From: Richard Sherman
Sent: 27 October 2021 15:09
To: Planning Scanning
Subject: FW: FG/151/21/CLP - 9 Telgarth Road, Ferring

Re. your application.

S01 :: Proposed Section
A03 scale: 1:100

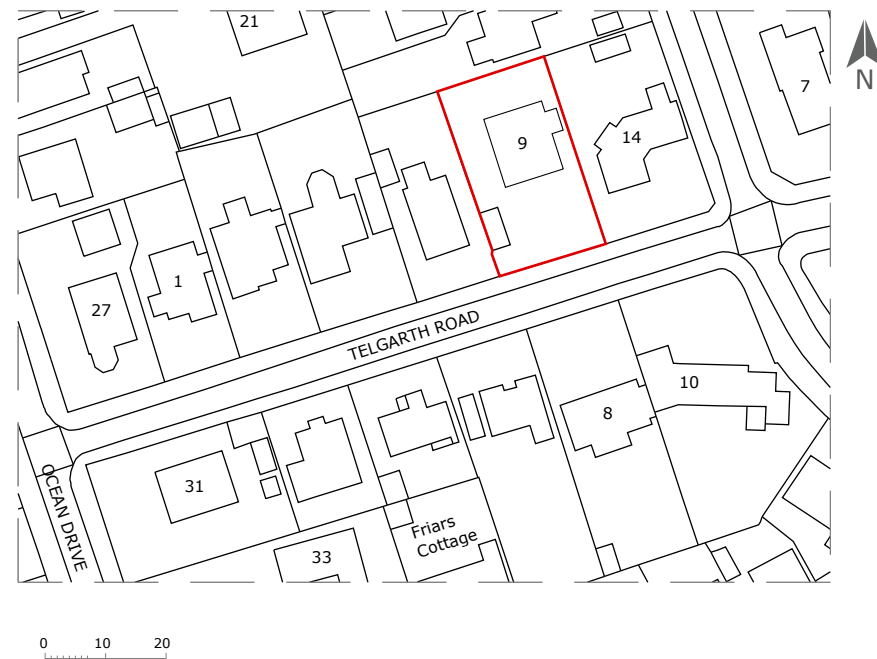
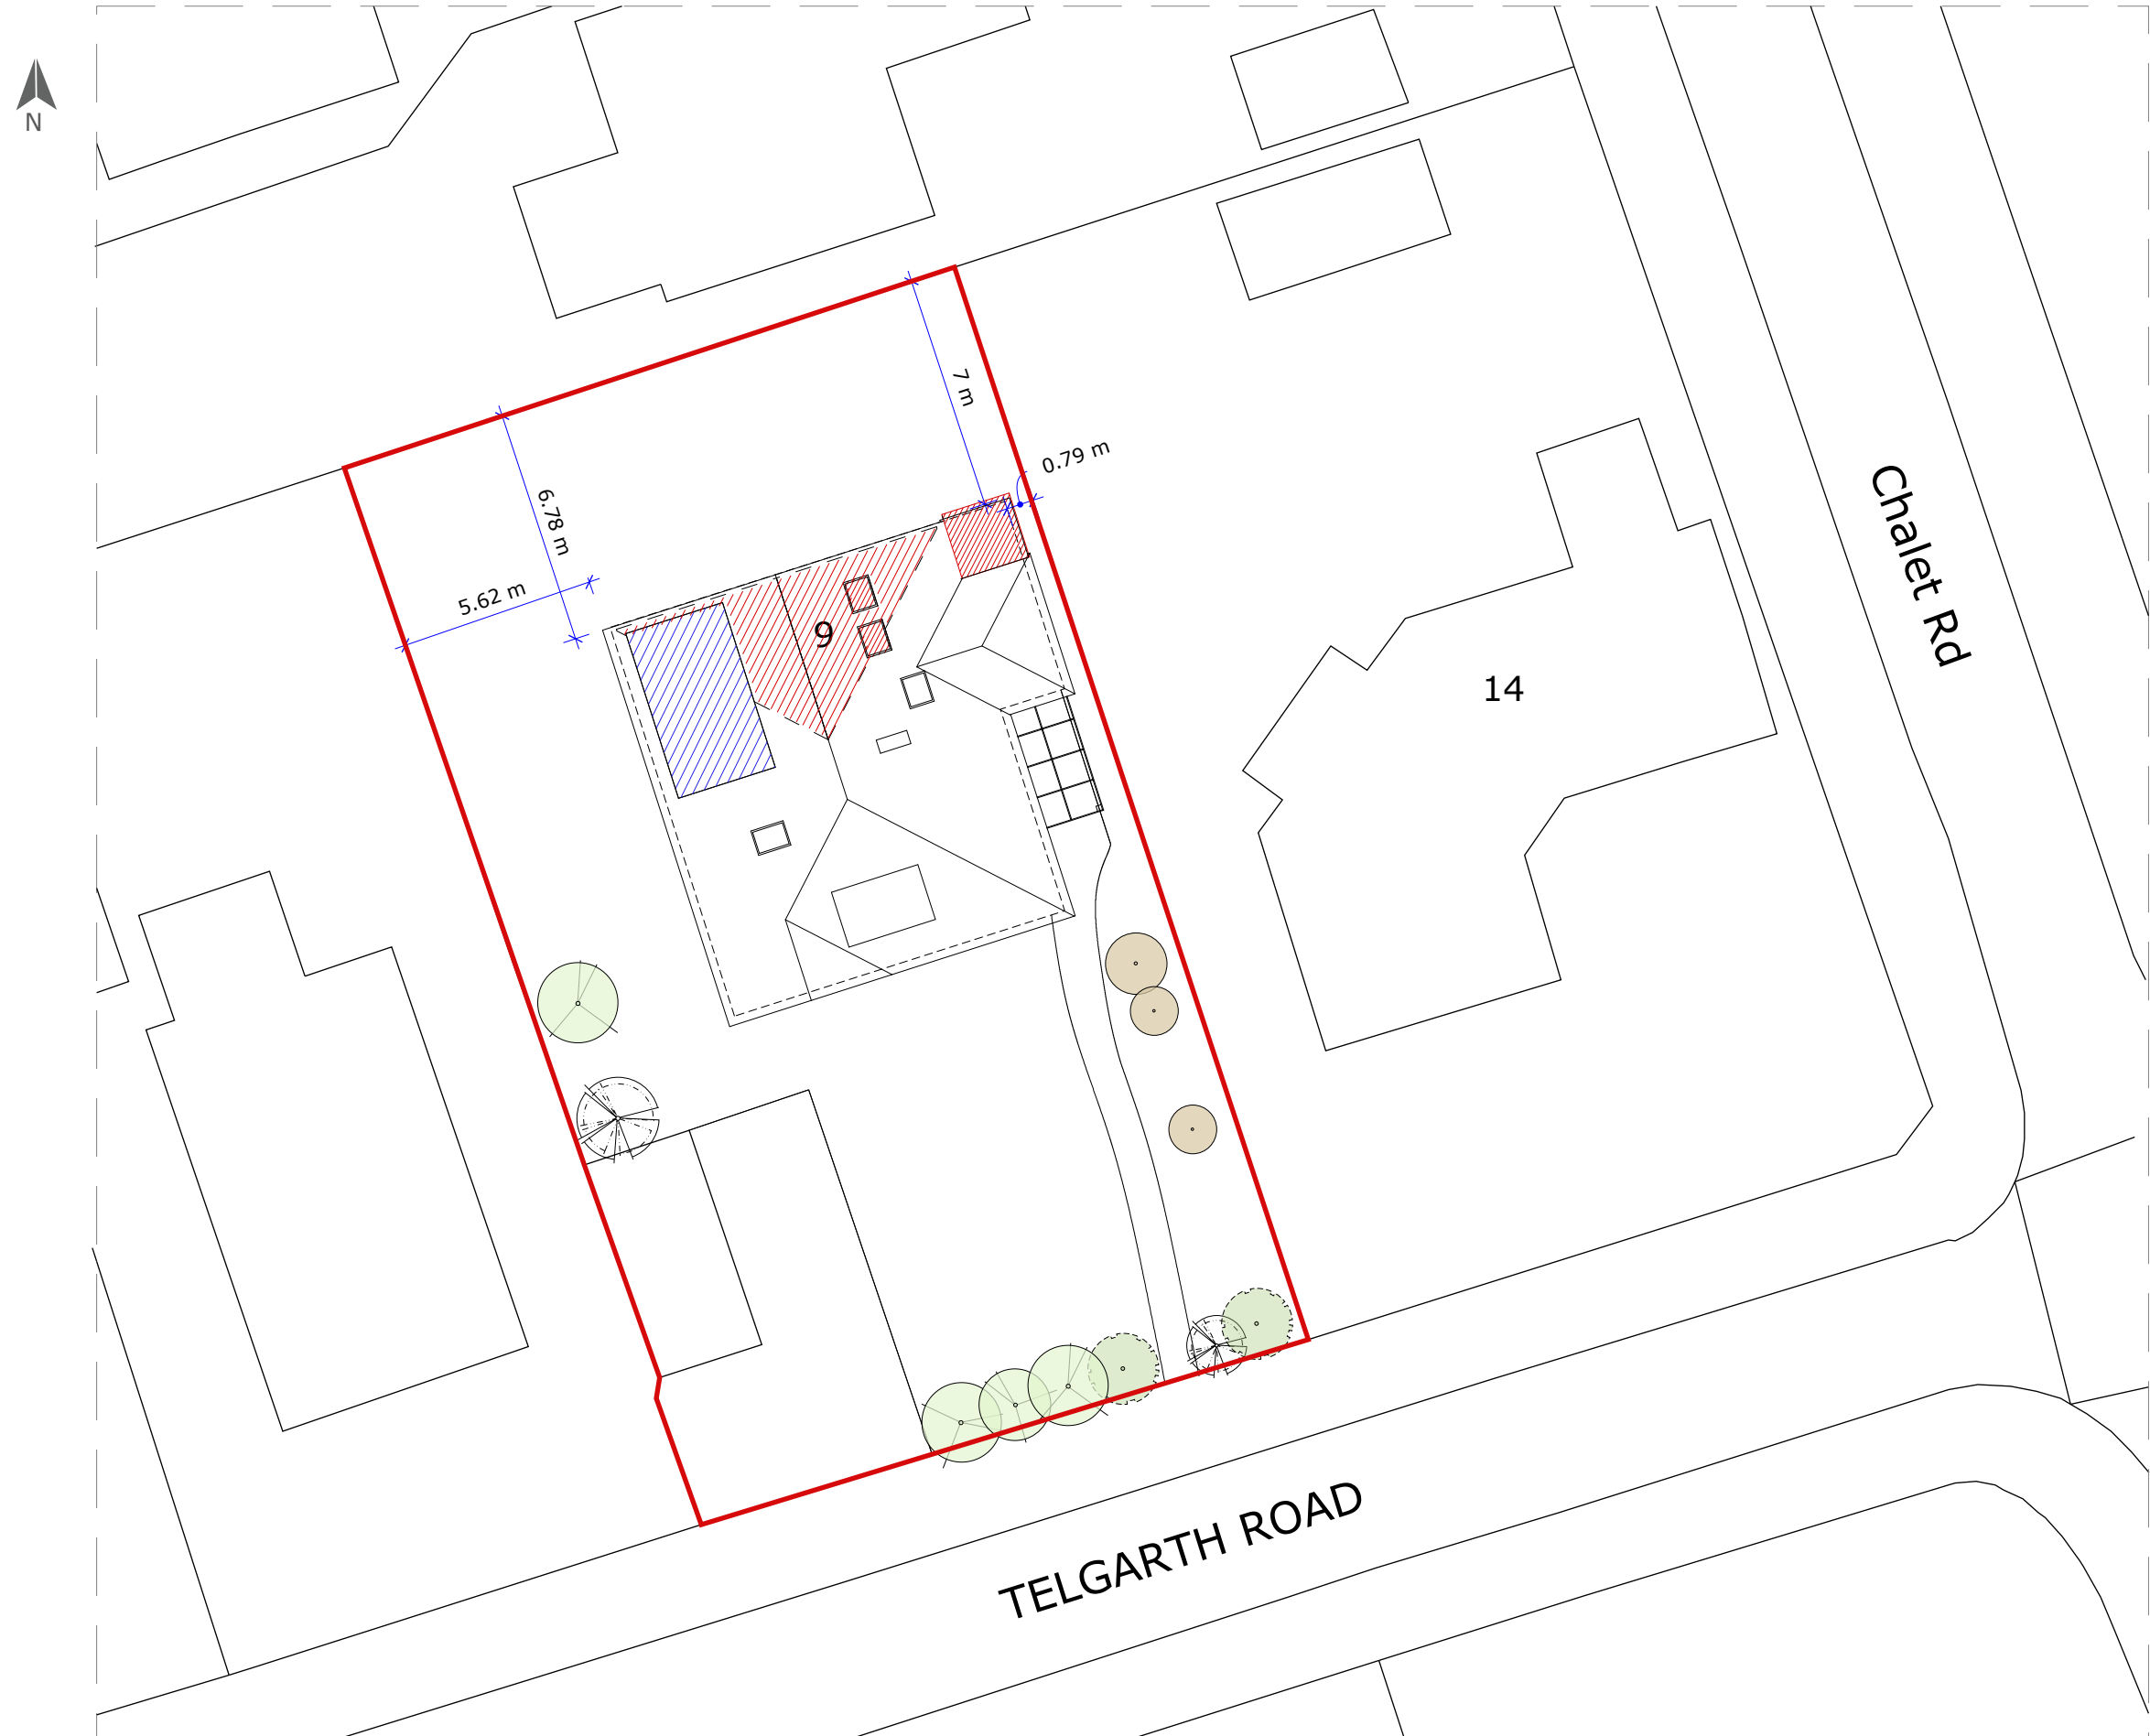
Also please can you send me in a cross section plan so we can work out the height of the two new proposed Velux windows? As we can't work out whether they are 1.7m above the internal floor level of the room of which they are to be installed?

A 04

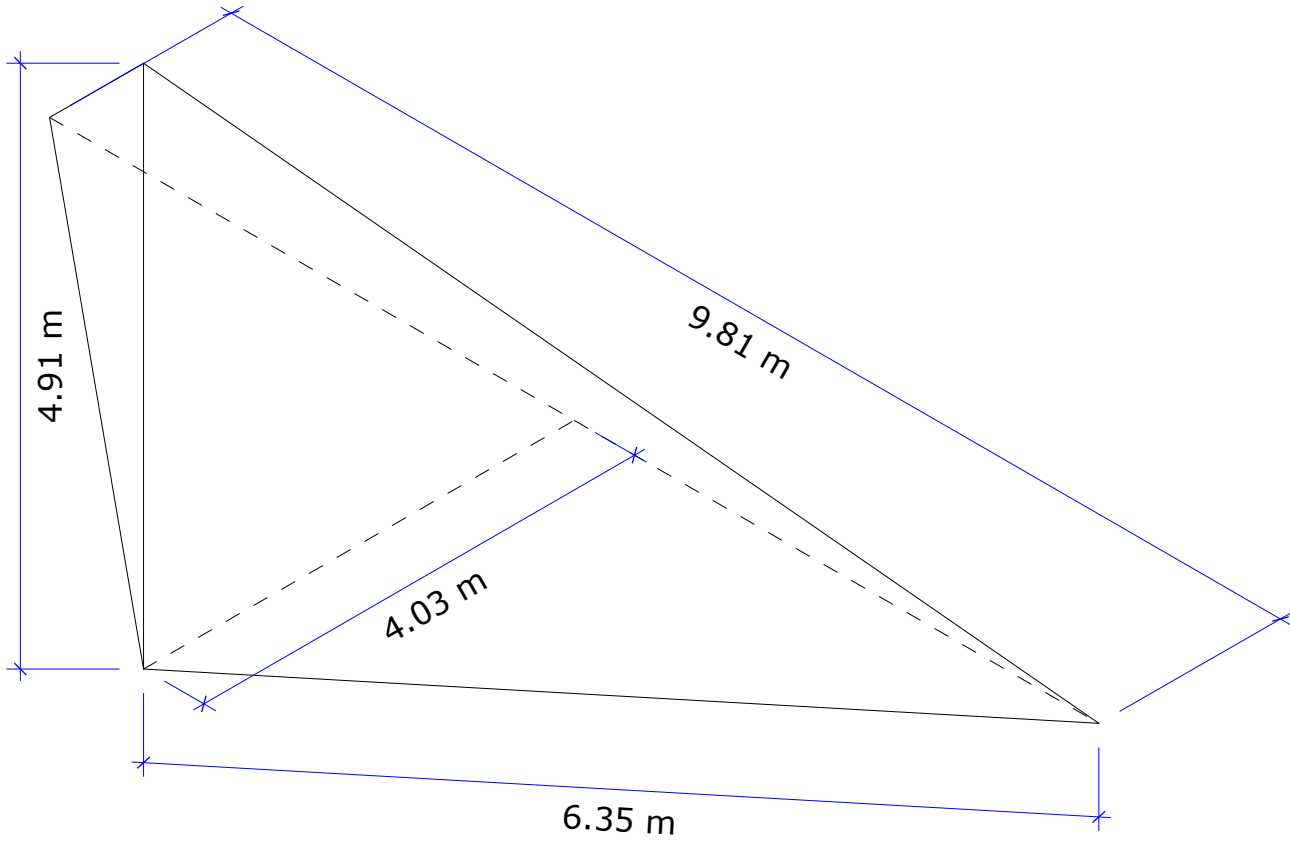
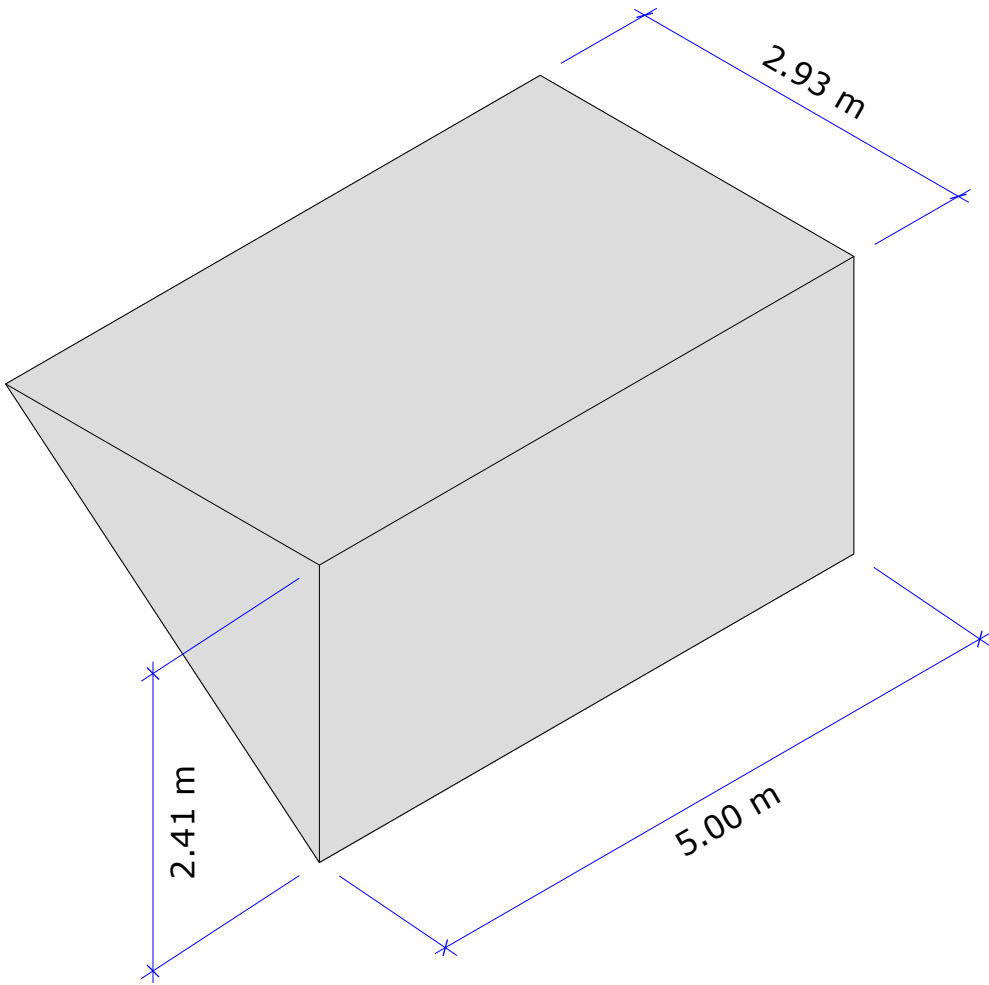
Unfortunately due to IT technical issues I cannot measure plans on my Laptop so I cannot work out the proposed volume of the new roof extension and dormer window. Therefore please can you send me in a drawing of the proposed plans with the measurements on them?
